## Department of Planning Industry and Environment

**Re: Response to Submission – Built Heritage  
Cockle Bay Park SSD 9978934 and SSD 7684-Mod-1**

This letter responds to the built heritage submissions received from the EIS for the Cockle Bay Park SSD 7686 and SSD 7686-Mod-1.

## Podium North

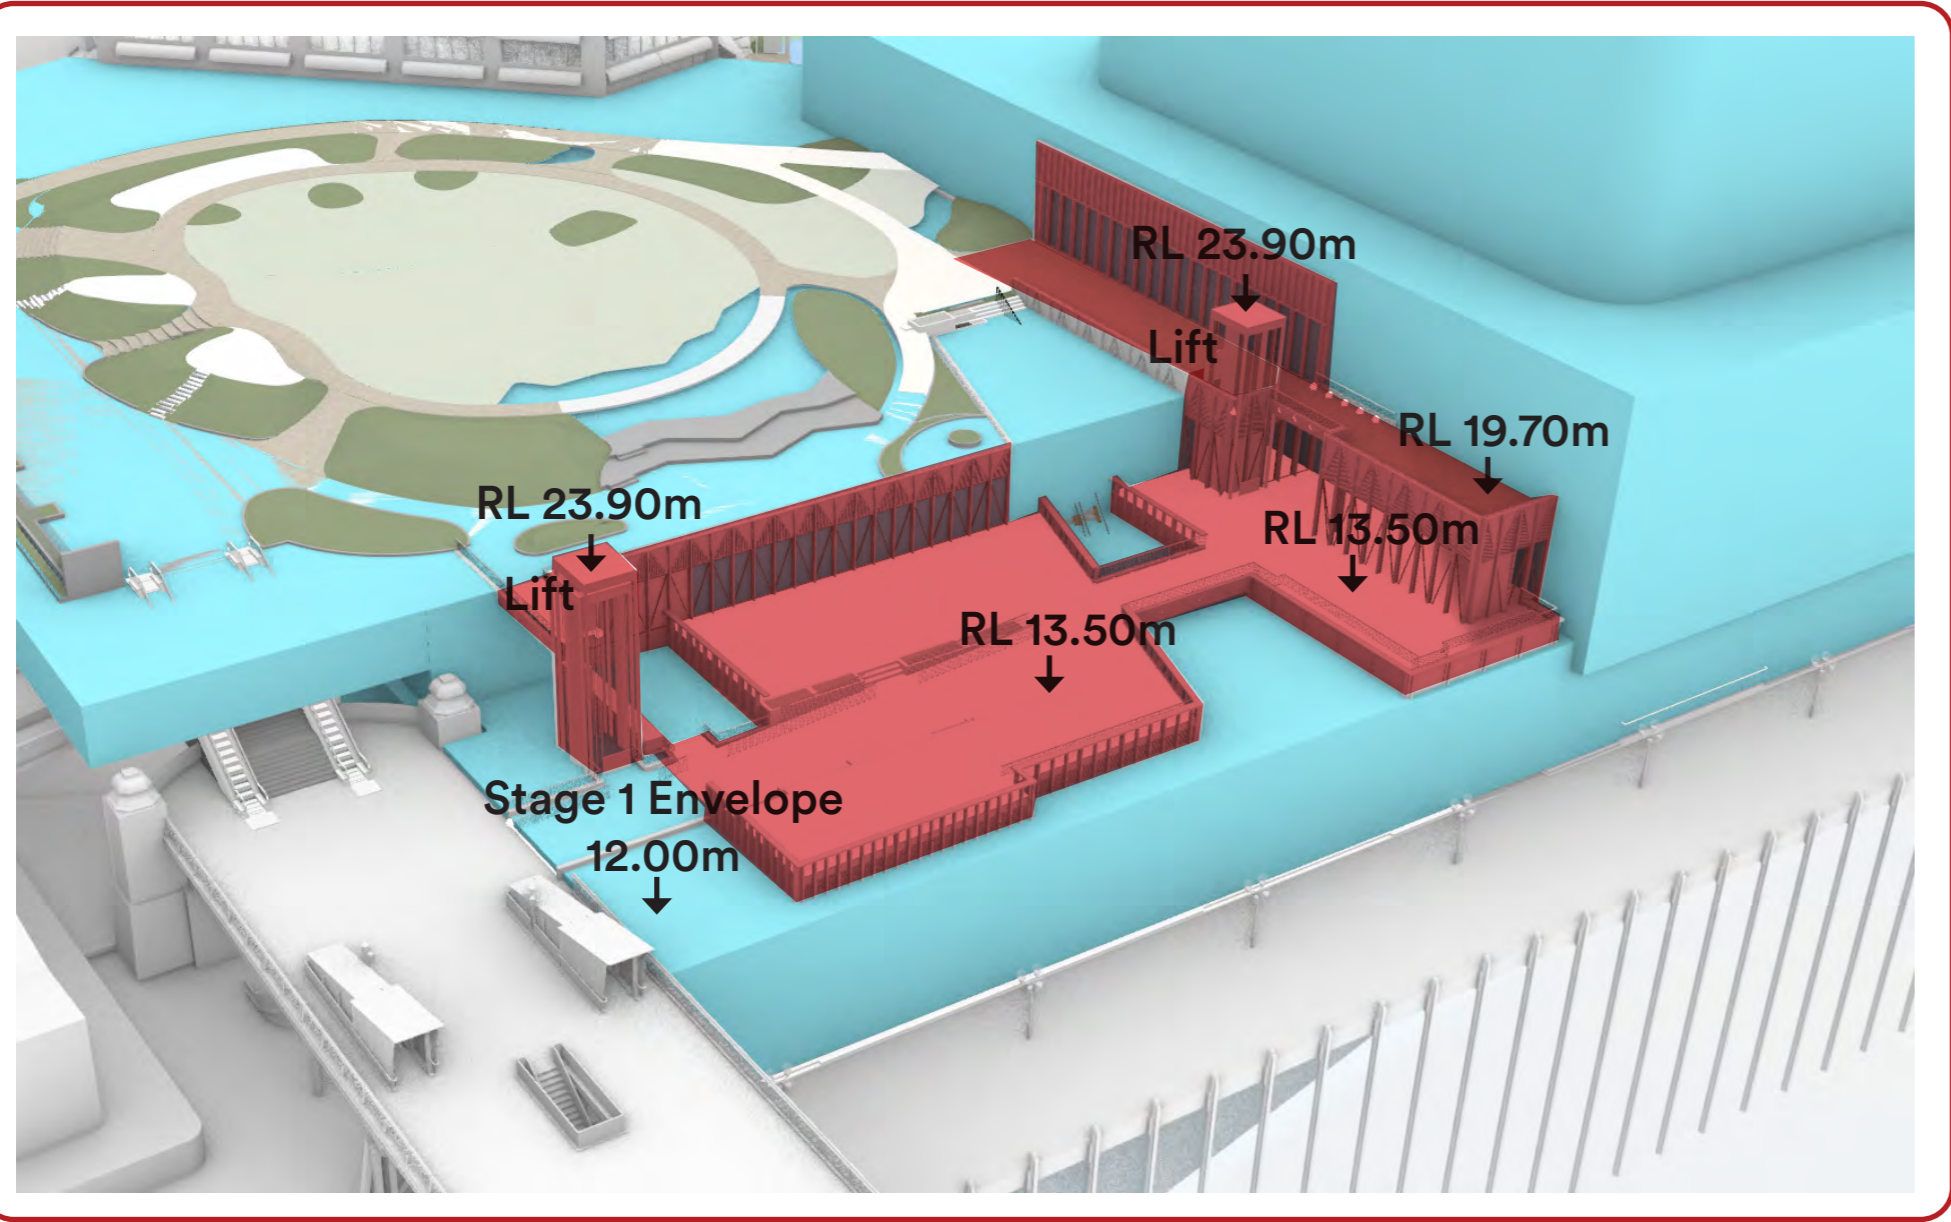
Issue	Response
<b>Department of Planning, Industry and Environment</b>	
<b><i>Changes to the building envelope</i></b>	
<p>The Department raises concern about the potential heritage and visual impacts resulting from the increased height of the building envelope (from RL 12 to RL 13.5) and provision of a lift structure adjacent to the Pymont Bridge.</p> <p>Concern is also raised about the location of escalators/stairs connecting to Pymont Bridge. The design of the building envelope should be reconsidered to address these concerns, as well as the concerns raised in Council's and Heritage NSW's submissions about these impacts (also see points 6 and 7 in Schedule 2).</p>	<p>C) The increase to the height building envelope is limited to the northern portion of the retail area adjacent to the Pymont Bridge. Overall, the building envelope has been reduced to formalise the setback with the Pymont Bridge. This has an improved heritage impact as there is no possibility of any built form encroaching further onto the eastern approach to the Bridge. Views towards the southern side of the eastern approach are significantly improved by the setback of the envelope allowing a full appreciation of the southeastern approach of the bridge. The increase in height as viewed from the bridge deck looking to the southeast it largely mitigated by the proposed separation which will allow the retail area to read as part of the wider development backdrop. From a design perspective the proposed increase in height is driven by the following requirements:</p> <ul style="list-style-type: none"> <li>i. There is a minimum requirement for sufficient height in retail areas in the podium below. Any reduction in the height (existing 3.6m) will not allow adequate height for a quality retail space. While there is a height increase in the building envelope and built form is setback from the southern end of the Pymont Bridge to ameliorate much of the impact with regard to height.</li> <li>ii. The diagrams and photomontages provided in Stage 1 - SSD 7684 MOD 1 design pack prepared by Henning Larsen (refer to the RTS package prepared by Ethos Urban) response further highlight how the impact of the increased height of the retail spaces is mitigated by the setback of the entire envelope from the southern side of the Pymont Bridge.</li> </ul> <p>As such, the proposed design modification to address The Department's concerns regarding increase the setback of the podium adjacent to Pymont Bridge have been addressed</p>

Issue	Response
<p>This needs to be further explained through diagrams as the extent of this improvement is unclear from the documentation submitted. The area of the SHR curtilage affected should also be clearly demarcated in the drawings.</p>	
<p>C10.</p> <p>Future Development Application(s) shall include a detailed Heritage Impact Assessment, which considers the heritage impact of the development including any visual and built heritage impacts on Pymont Bridge, Corn Exchange and Shelbourne Hotel. The Heritage Impact Assessment must include appropriate mitigation measures to address any adverse impacts.</p> <p>Options to relocate the proposed escalators further back from the significant bridge stone piers should be explored to achieve a more sympathetic interface with the Pymont Bridge, which minimises visual and physical impact.</p> <p>The proposed new lift structure in the immediate vicinity of the bridge should be reconsidered in terms of its location, form and scale to minimise visual impact on Pymont Bridge.</p> <p>Extent of 'improvement' (as noted in Attachment A Building Envelope Modification Design Report) to the approved Concept Proposal with regard to impacts on Pymont Bridge, shall be further explained through diagrams. The area of the State Heritage Register curtilage affected should also be clearly identified and demarcated.</p>	<p>Any future Development Application will include a detailed visual and heritage impact assessment which will consider the impact on the Pymont Bridge, Corn Exchange, and Shelbourne Hotel.</p> <p>The remainder of responses for C10 are addressed in the commentary above or through separate appendices.</p>

<p>The Report further states that: The updated scheme has pulled the built forms away from the Pymont Bridge heritage item as an improvement to the approved Concept Proposal and the competition scheme that had more built volume encroaching on this space.</p>	<p>The diagrams and photomontages provided in SSDA MOD response further highlight how the impact of the increased height of the retail spaces is ameliorated by the setback of the entire envelope from the southern side of the Pymont Bridge.</p>
